**KIRKLEES METROPOLITAN COUNCIL
INVESTMENT & REGENERATION SERVICE**

DELEGATED DECISION TO DETERMINE PLANNING APPLICATIONS

Reference No:	2022/62/93245/W
Site Address:	adj, Marsh Conservative Club, Abb Street, Marsh, Huddersfield, HD1 4PB
Description:	Erection of two semi-detached dwellings
Recommending Officer:	Luke Walstow

OFFICER REPORT

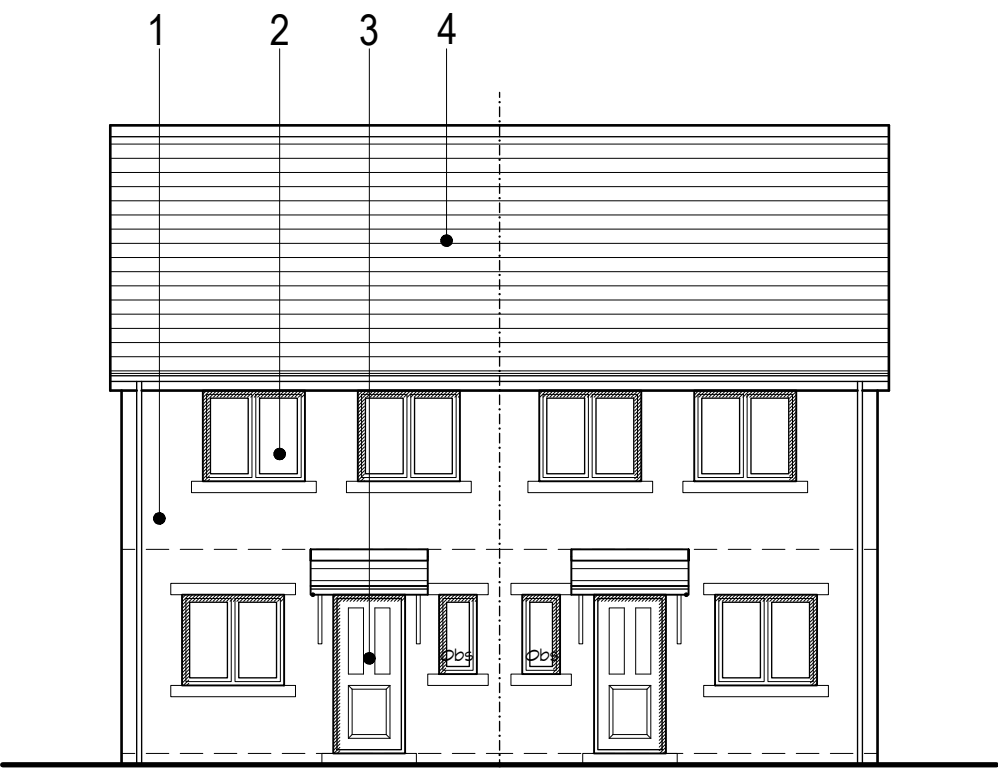
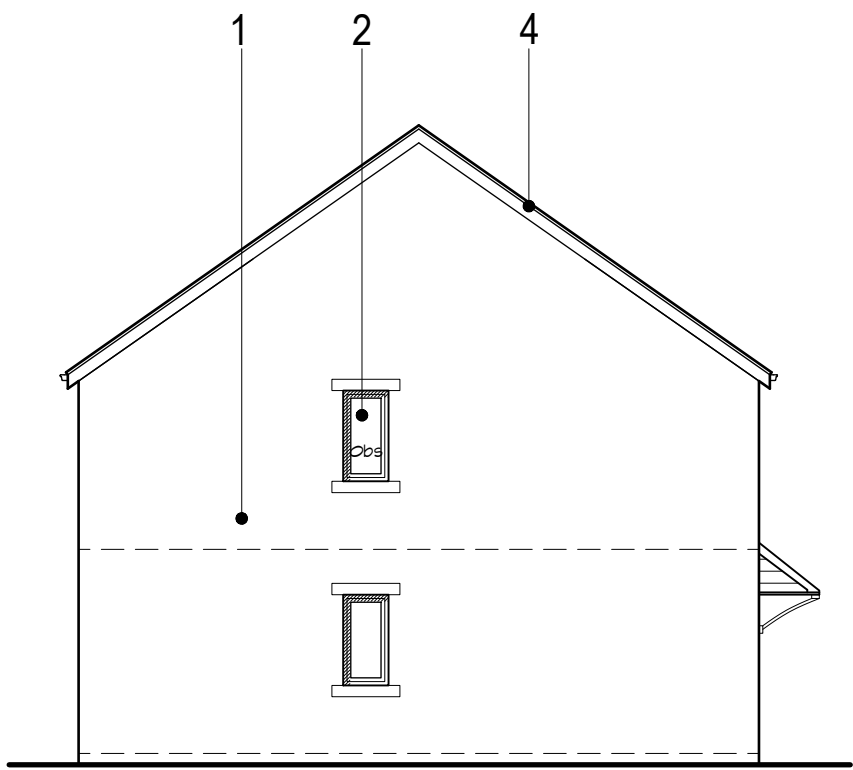
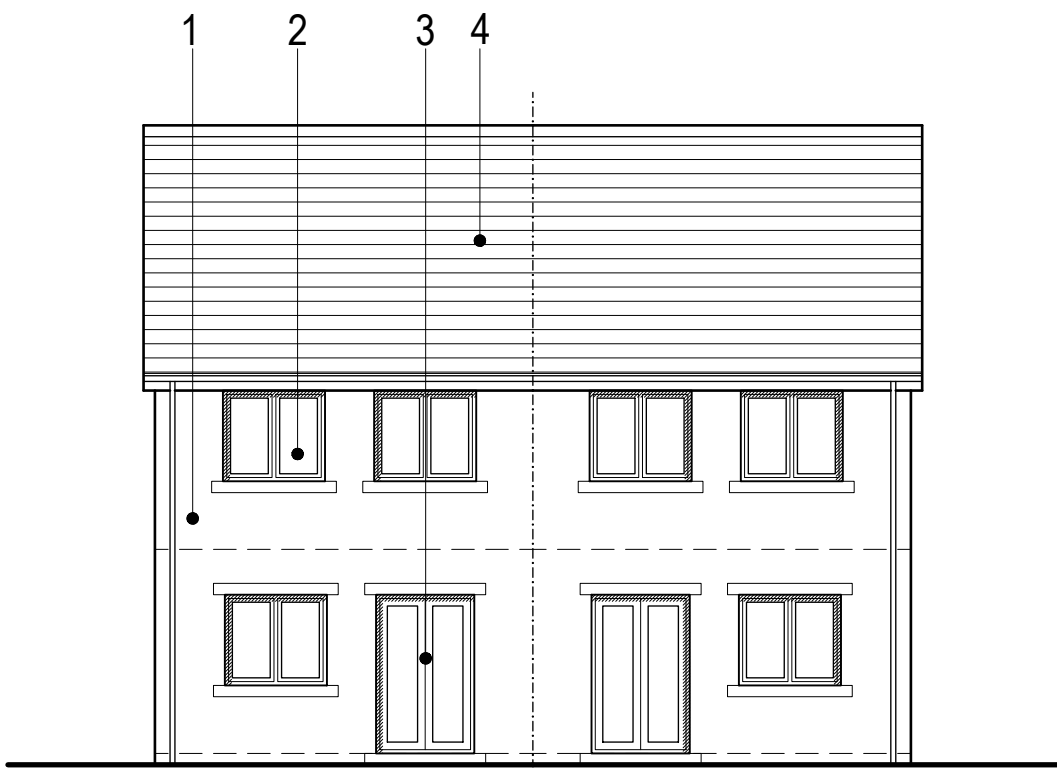
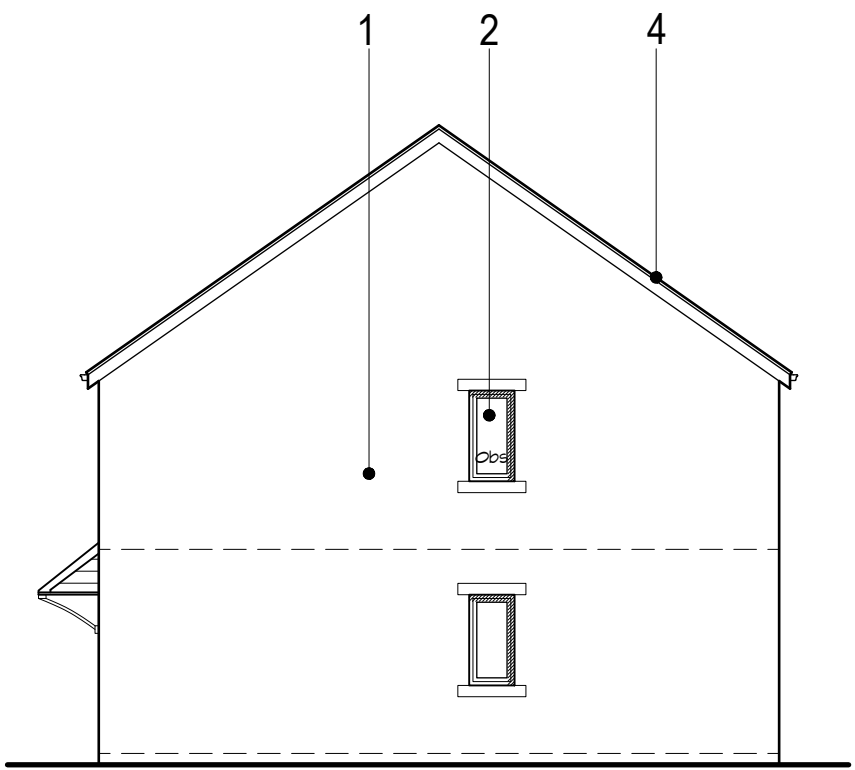
Marsh Conservative Club is a large detached public building located to the North of the application site. There are two windows proposed on the northern elevation of the northern dwelling, which would be on the boundary of the Conservative Club. These serve as a secondary window to a living room at ground floor and bathroom window at first floor. On the basis adequate screening is in place to the boundary, which could be secured by condition, it is considered these openings would not lead to an unacceptable level of overlooking occurring.

12 to 22 Syringa Street are terraced houses located to the south of the application site. There would be a separation distance of 11.1m at the closest point between the rearmost point of these dwellings and the side of the proposal. A road is between the boundaries. This facing elevation of the proposed dwellings will have two small windows on ground and first floor levels. This distance is considered to be acceptable in this case given the orientation of the dwellings in relation to the proposal and on the basis adequate screening is in place to prevent overlooking from the ground floor secondary window serving a living room. As such the proposal is considered to have an acceptable impact on privacy, being overbearing and not significantly impacting upon the outlook of nos 12 – 22.

1 Proposed Site Layout
1 : 200

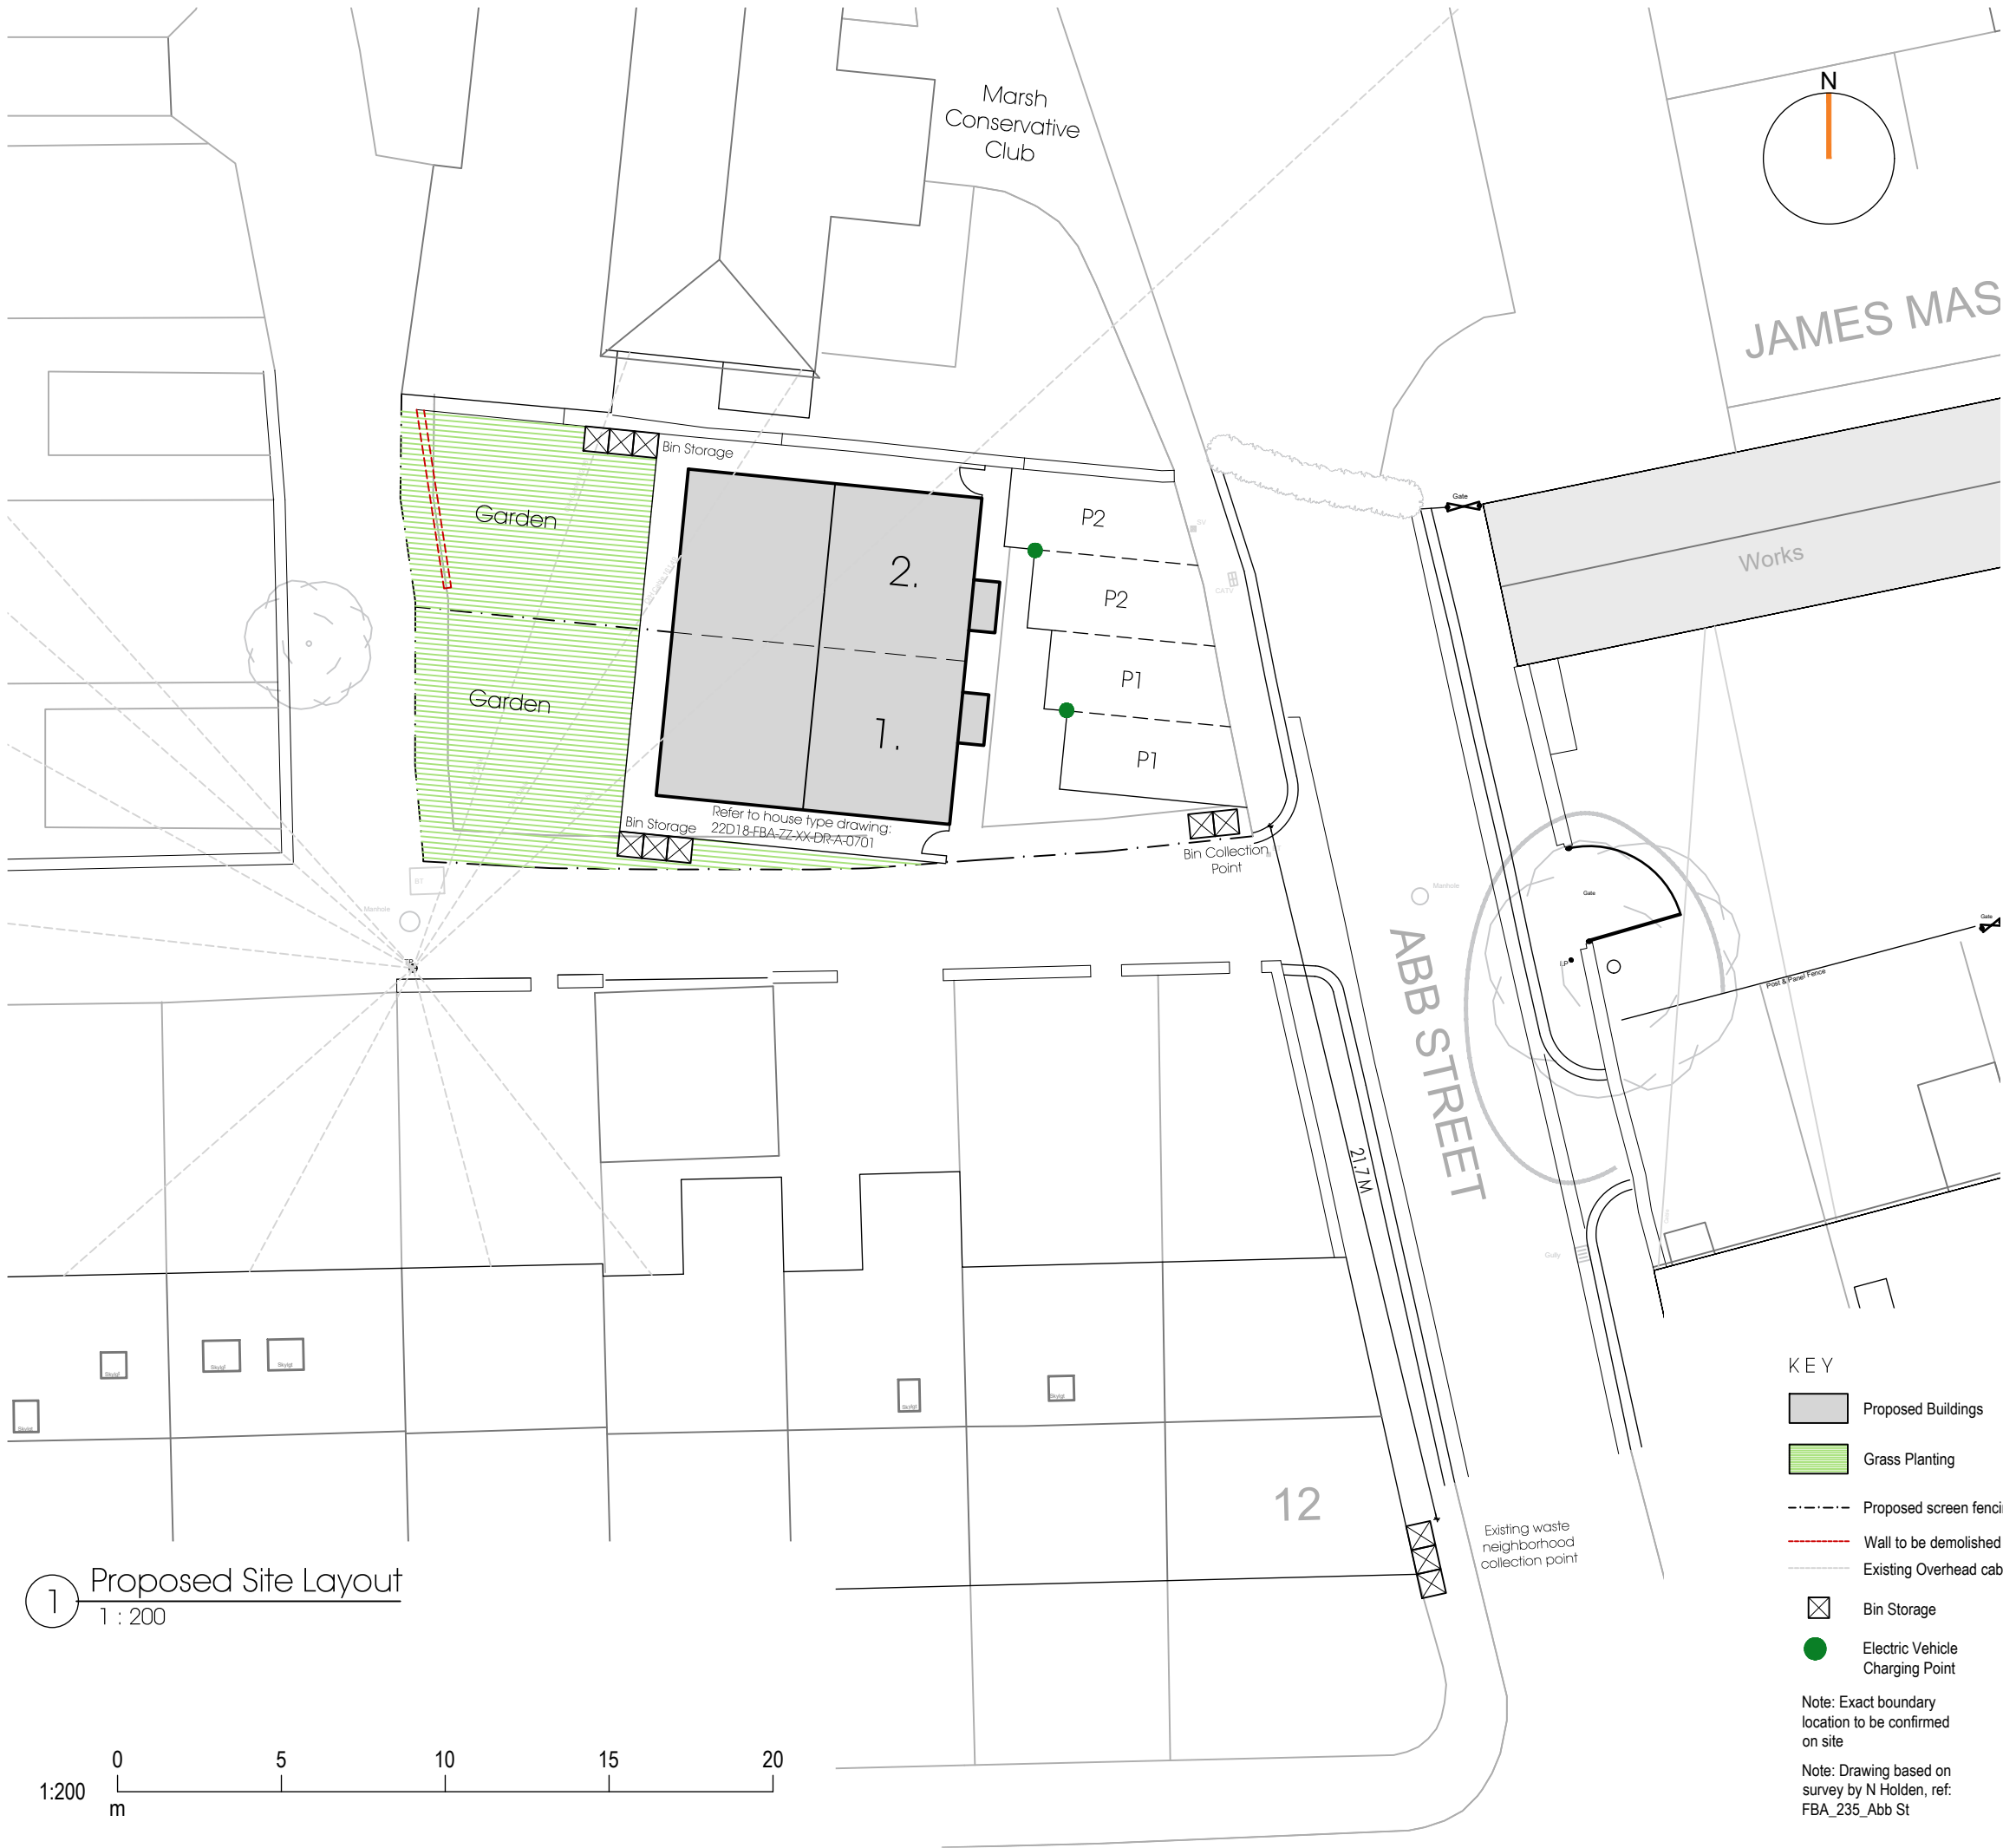
KC Highways were consulted on the application and stated given the previous approval from Highways Development Management on application 2019/91609, they have no objection in principle. They did raise concerns over access to the northern parking space of plot 2, saying it may be difficult to manoeuvre and turn into the space. The agent provided photos of the site and where the space parking space would be, which resulted in the highways team stating the verge needs to be tarmacked to allow access into the parking space.

Whilst utilising the northernmost parking space could potentially see use of a grass verge area to the north east of the site it is considered that the access would be gained over an area which is already tarmac and whilst some manoeuvring would be required, it is considered possible to access this space without utilising this verge area. Furthermore, given this space is to the northernmost part of a cul de sac, it is considered manoeuvres being performed to access this space would not significantly impact on the operation of the highway. As such it is not considered necessary to include a condition requiring the verge outside of the site to be hard surfaced.

KC Highways also asked for evidence in how bins would be presented on collection day without obstructing the highway or proposed driveways. This was shown on an amended plan submitted by the agent, in which highways were satisfied.

Amendments to plans to show bin collection were sought due to highway concerns and provided on 06 January 2023.

Subject to the addition of conditions relating to the tarmac verges, the proposed development is therefore considered to be in compliance with policy LP21 and LP24 of the Kirklees Local Plan.
